### **Petrick Residence Extended Family, AL-18-025**

Please accept the following comments from El Paso County Public Health for the second residence project referenced above:

**Mike McCarthy, R.E.H.S.**  
**El Paso County Public Health**  
**Environmental Health Division**  
**719.575.8602**  
**[mikemccarthy@elpasoco.com](mailto:mikemccarthy@elpasoco.com)**  
**25Nov2018**

**SITE PLAN**  
SCALE = 1:30

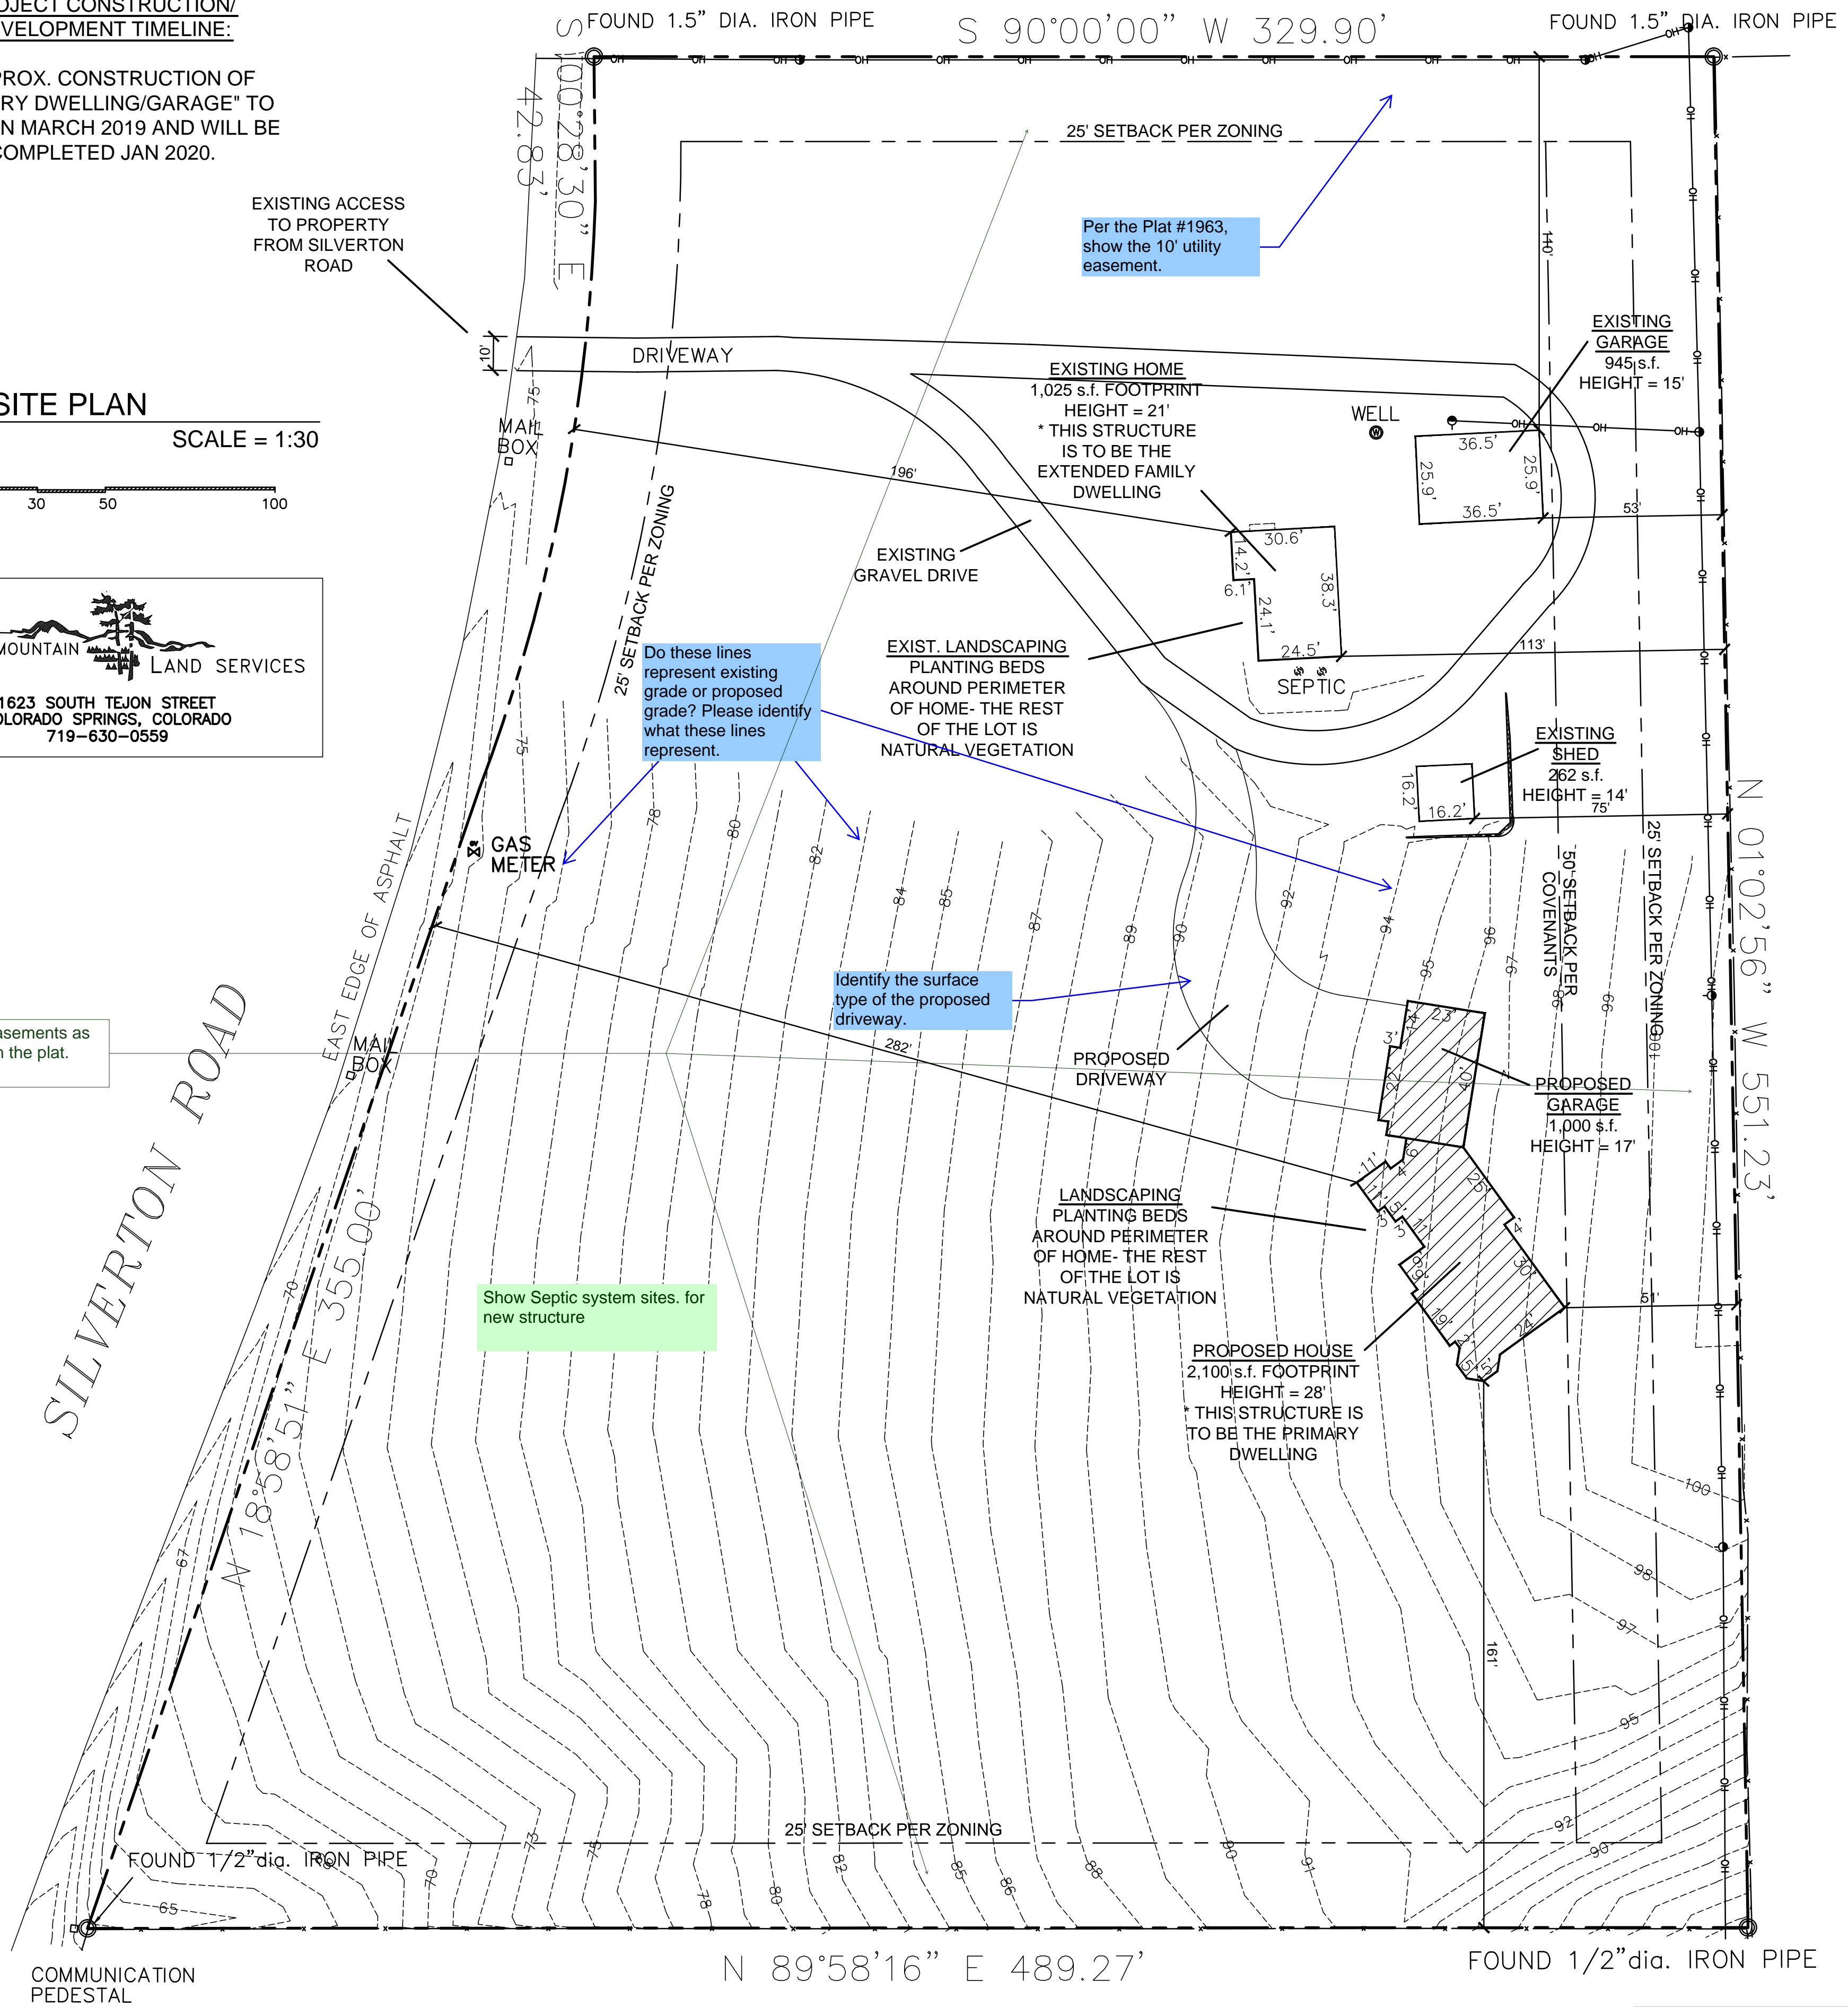
- **Water service for the existing house and the proposed second residence is by an existing individual well.**
- **Wastewater service for the existing house is provided by an onsite wastewater treatment system (OWTS) that was installed in 1973 and sized and approved for a 4-bedroom house. This house is proposed to be considered the “Guest House” if the proposal is approved.**
- **A New OWTS Permit is required by El Paso County Public Health for the new second residence which is proposed to become the “Primary Dwelling”. Full compliance with Chapter 8 of the Board of Health Regulations governing Onsite Wastewater Treatment Systems is required. Minimum OWTS installation setbacks must be maintained both internal and external to the property lines.**
